Y/97/21/DOC

Bonhams Field Main Road Yapton BN18 0DX

Approval of details reserved by condition imposed under Y/63/19/RES relating to condition 5-details of construction & materials of all front openings, windows & doors for plots 2-7, 19-21, 36-41 & front & right hand side openings, windows & doors for plot 1

South-West Elevation

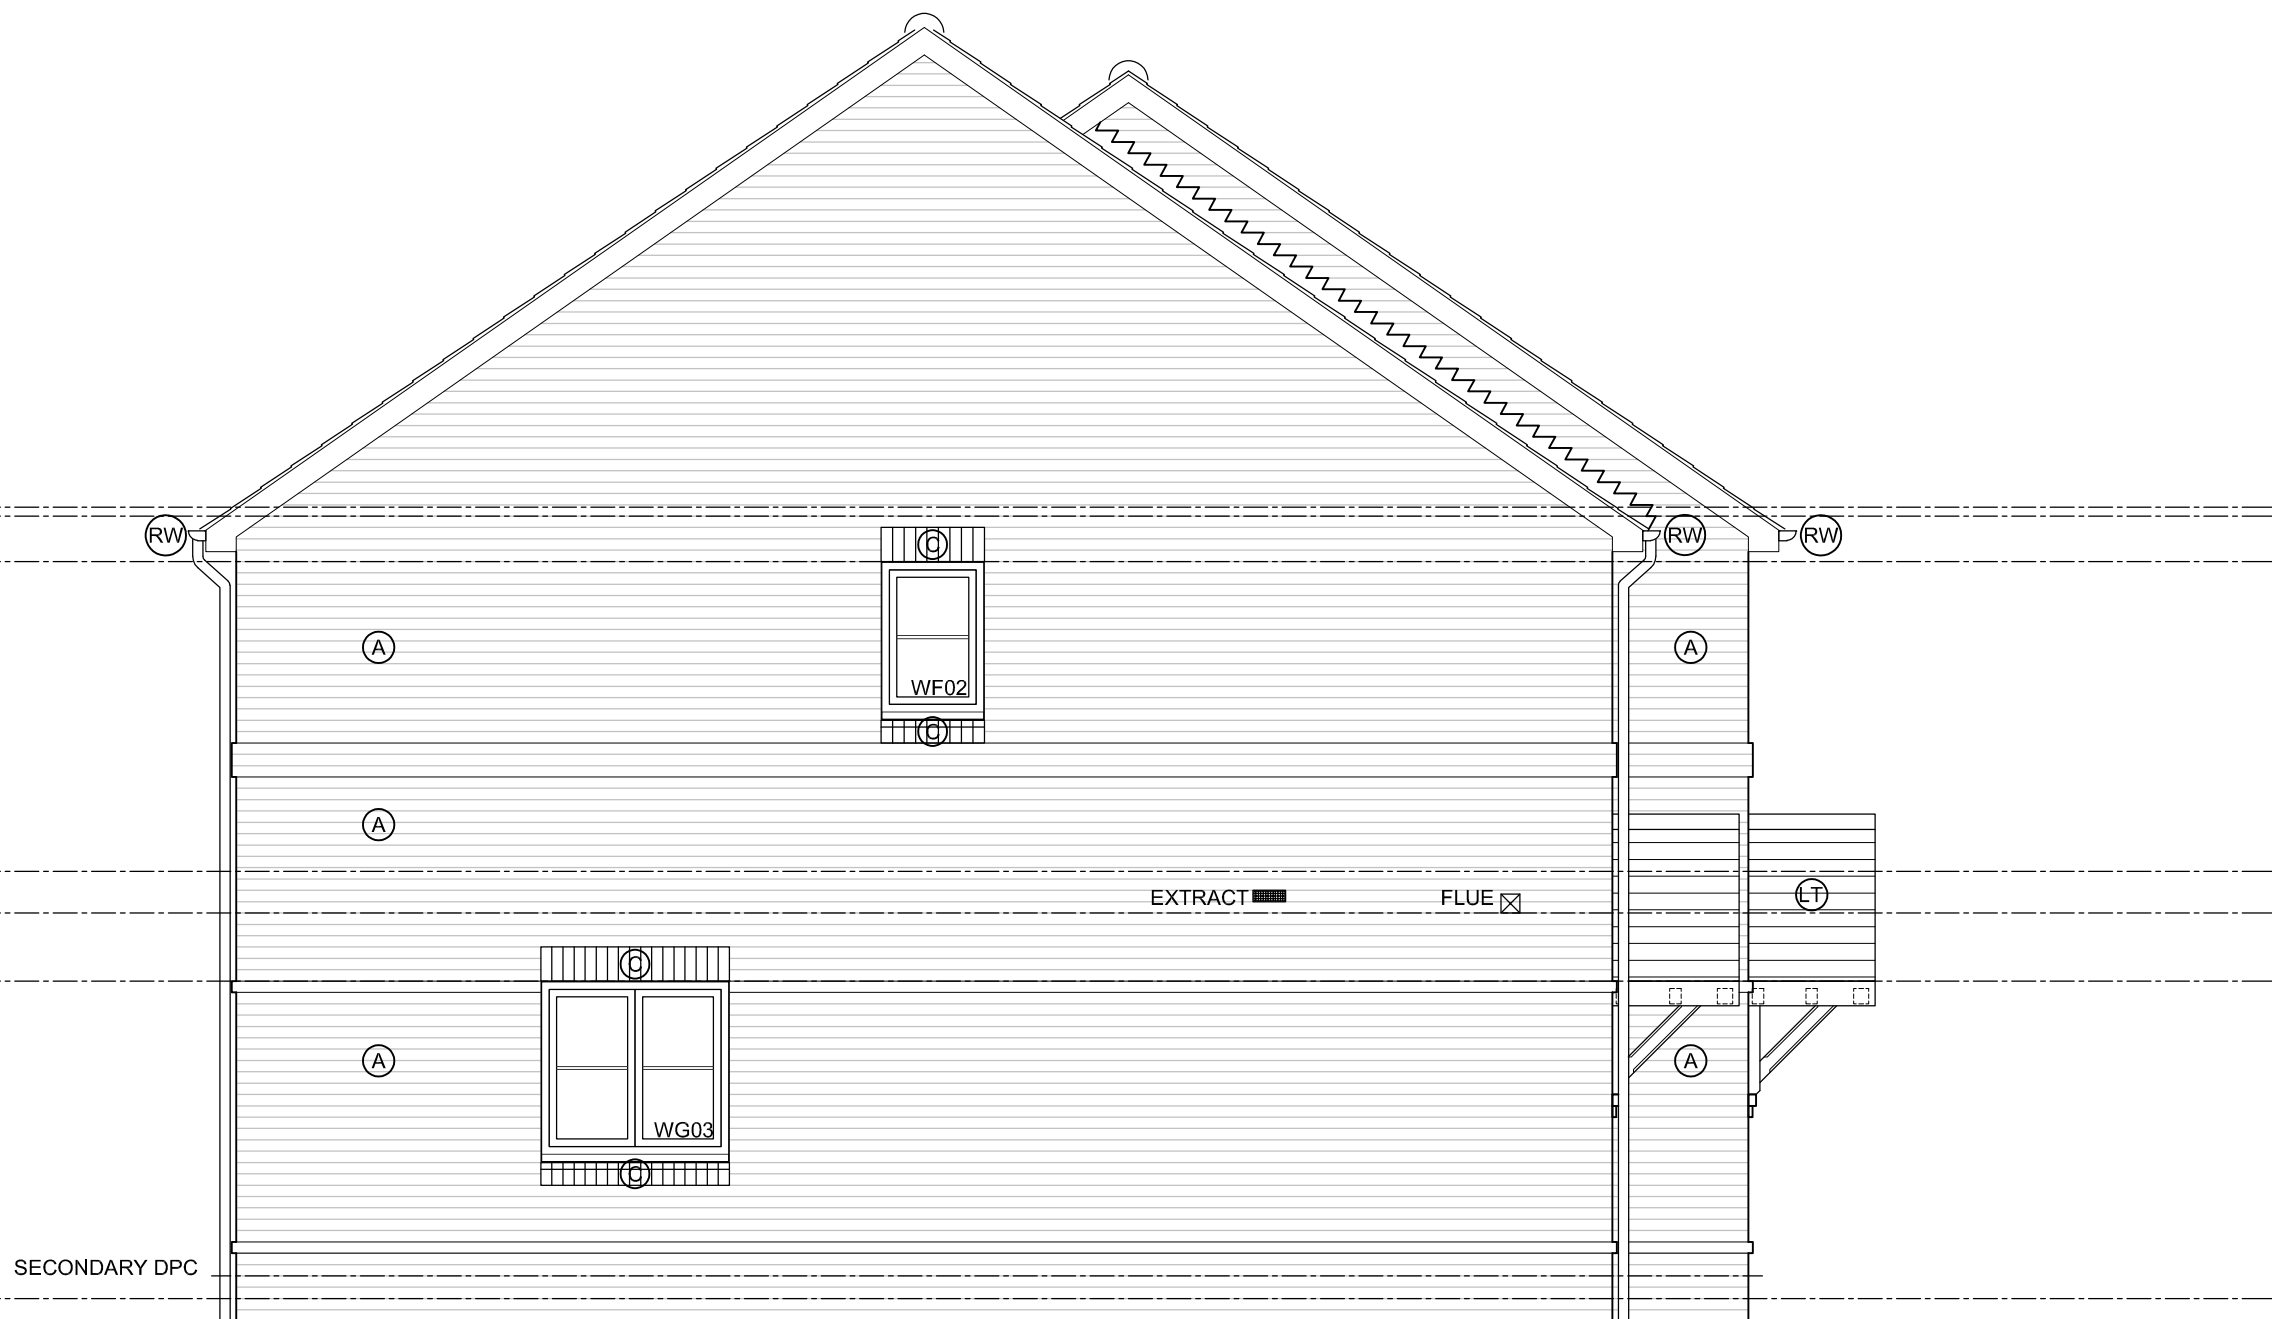
First of all it would have helped to have the general arrangement elevations of all of the units identified within the original condition as opposed to just six of them.

Plots 1, 2-7, 19-21, 36-41 are those closest to the heritage assets (listed buildings and conservation area). As a result, it was assumed that the intention was that those buildings should be constructed using traditional materials. The reason for this being to attempt to reduce the impact of the new development upon them. At present, this does not appear to be the case with the proposed materials etc. For instance the use of UPVC windows is disappointing, and cannot be supported.
